West Midlands Rail Freight Interchange Order 2020 (as amended)
Network Rail Infrastructure Limited's Response to the Proposed Non-Material Change Application

Network Rail makes the following representation in response to the proposed non-material change application submitted by Four Ashes Limited ("**the Applicant**") in relation to the West Midlands Rail Freight Interchange Order 2020 (S.I. 2020/511), as amended by the West Midlands Rail Freight Interchange (Amendment) Order 2023 and the West Midlands Rail Freight Interchange (Amendment No. 2) Order 2025 (together, the "**Order**").

The Order authorises the development of a Strategic Rail Freight Interchange, including a rail freight terminal with a direct connection to the West Coast Main Line, up to 743,200sqm of rail-served warehousing and associated highway infrastructure.

B2 - Proposed Road Bridge, Over Existing West Coast Main Line (Section S2)
(Scale 1:50)

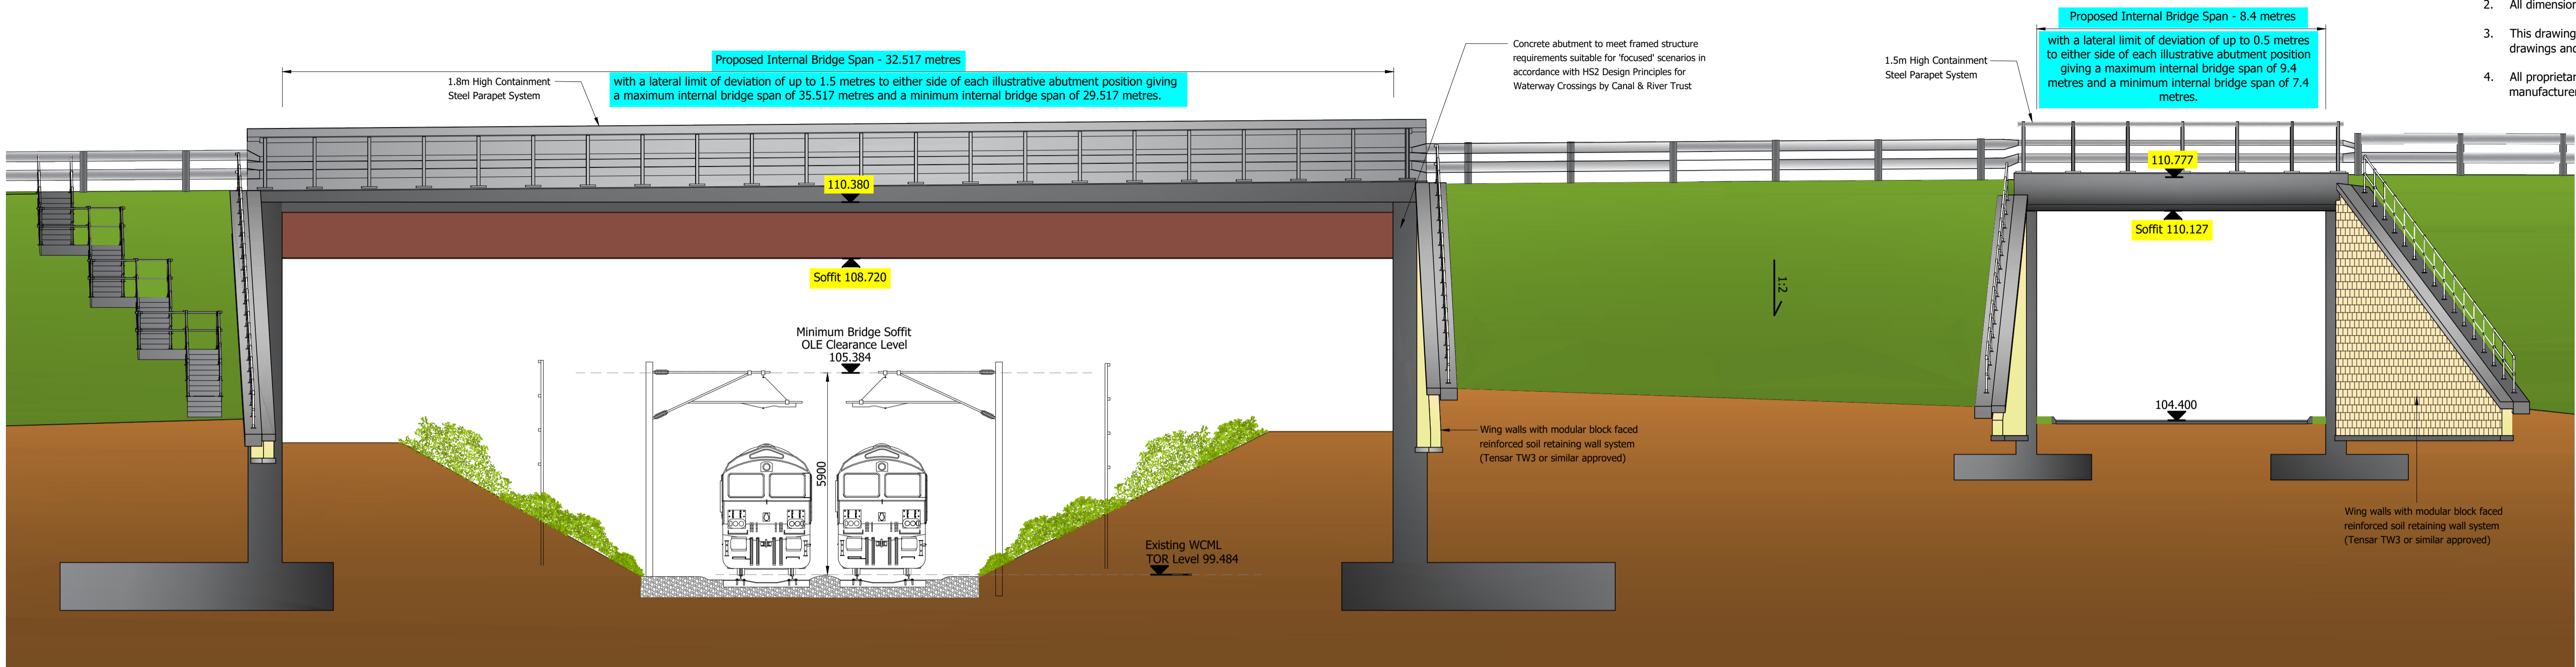
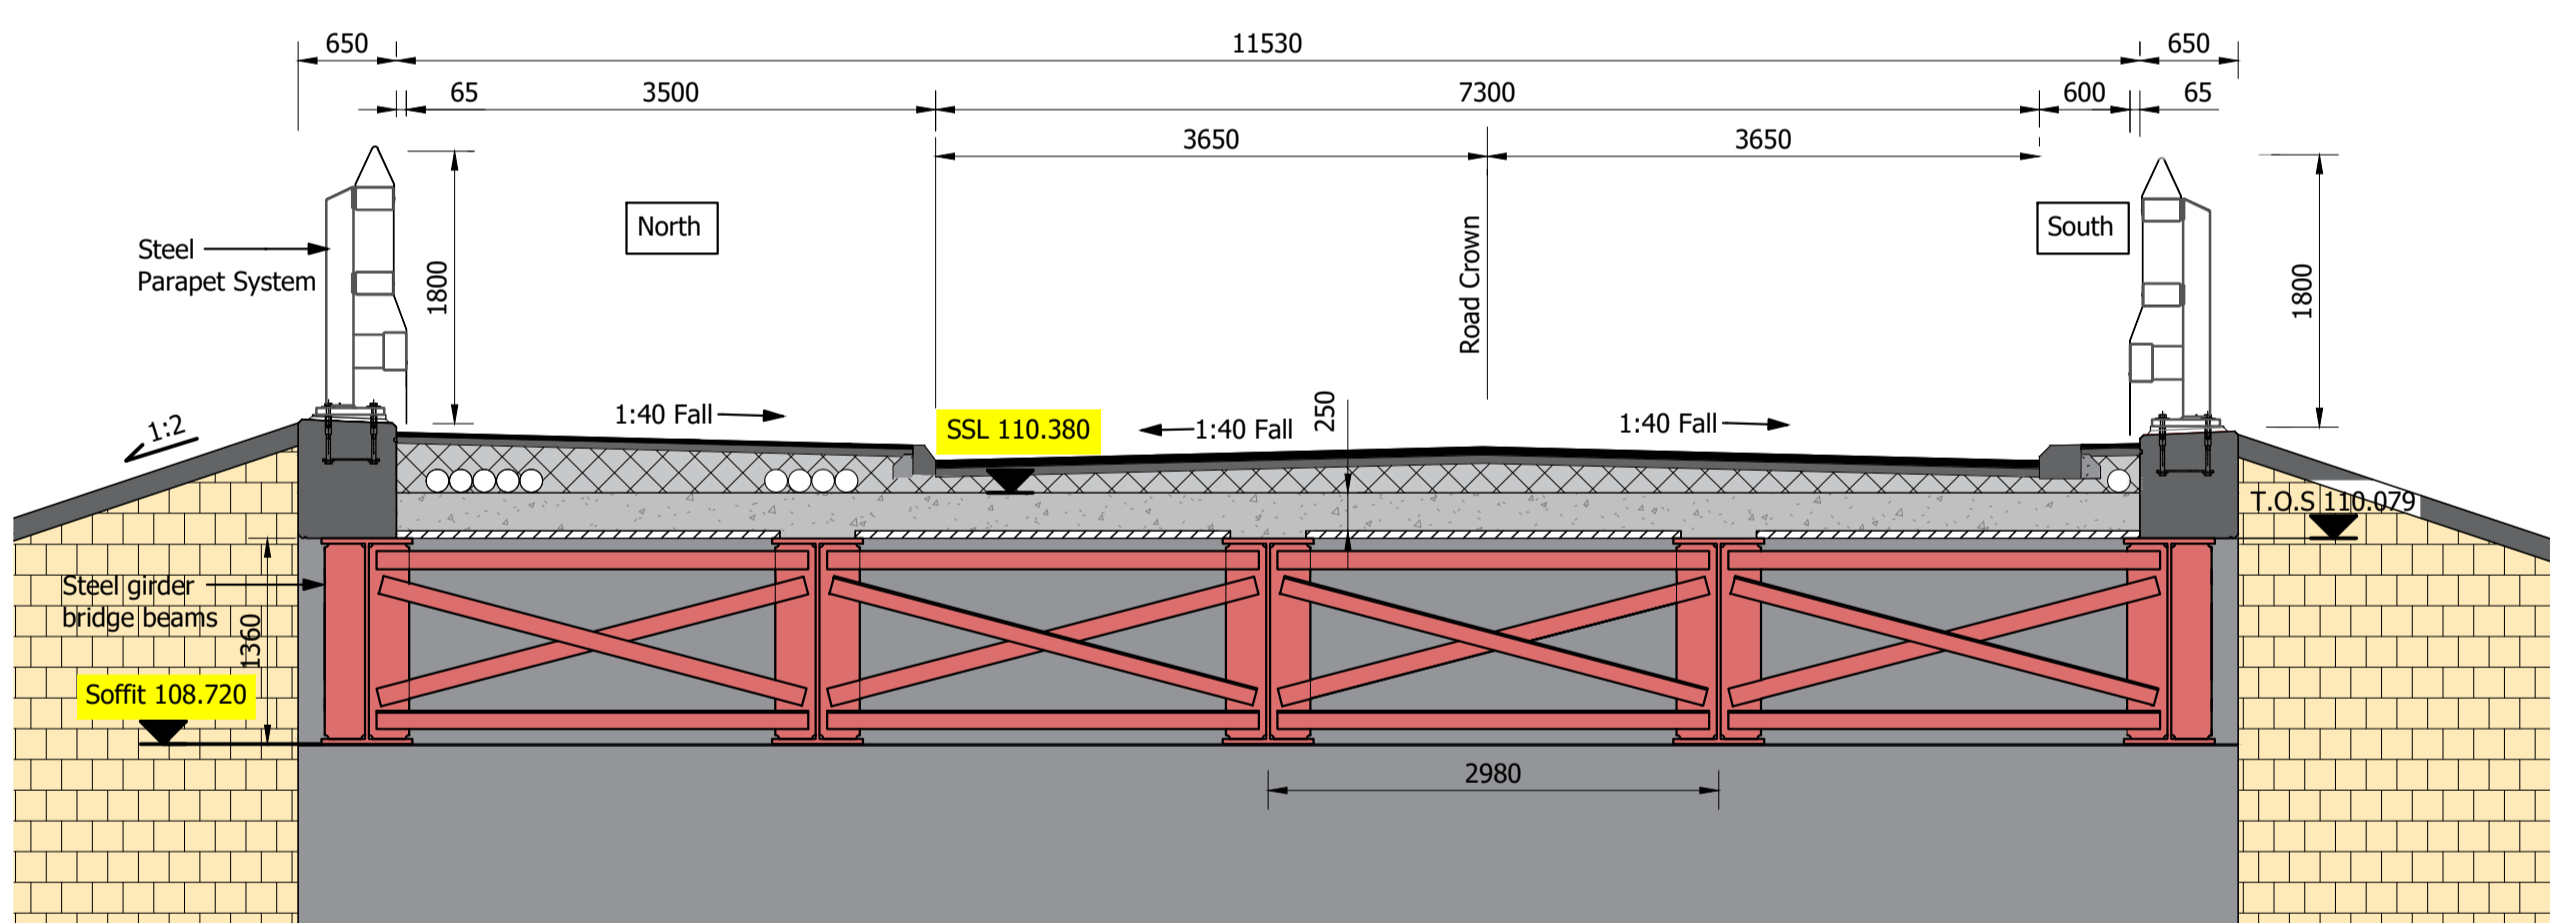
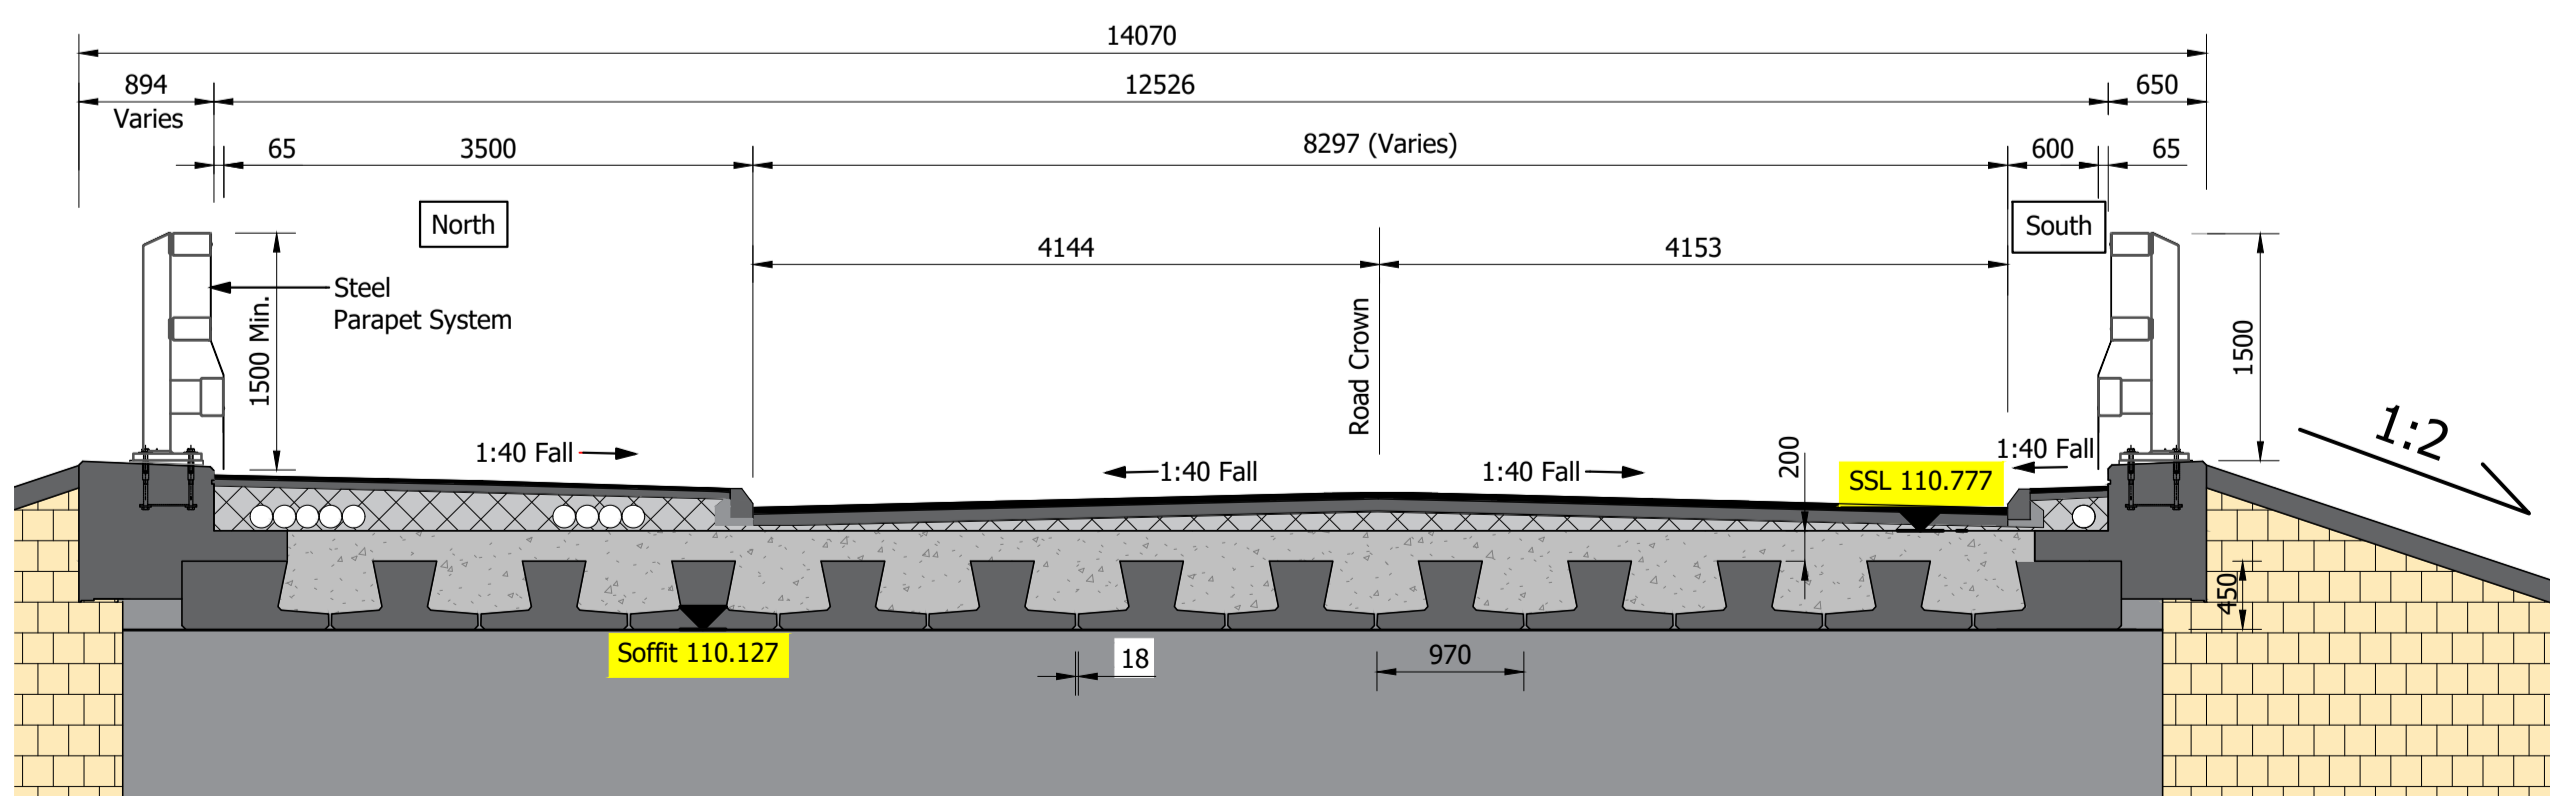
These two amendments have the effect of deferring the trigger for completion of the A5-A449 Link Road. As noted in the Application Statement, the Link Road is a complex element of infrastructure requiring the installation of four bridges spanning the railway, canal and highway network (paragraph 38, page 10). This includes the proposed replacement bridge crossing the West Coast Main Line.

Network Rail therefore seeks clarification from the Applicant as to:

- whether the existing Gravelly Way bridge has been assessed as suitable for continued use under the revised trigger regime;
- whether the existing bridge has been assessed against the forecast traffic volumes, vehicle types and loading likely to arise before the replacement bridge is delivered; and
- whether any mitigation measures are proposed to address any operational or safety implications arising from the delayed delivery of the replacement bridge.

This clarification is sought because the existing bridge is traffic-light controlled, narrow and single-lane in operation, with no vehicle incursion protection on the approach slopes or to the parapet walls, and the proposed amendments may result in increased HGV traffic movements utilising the bridge for a longer period than originally envisaged when the trigger regime in the Order was approved.
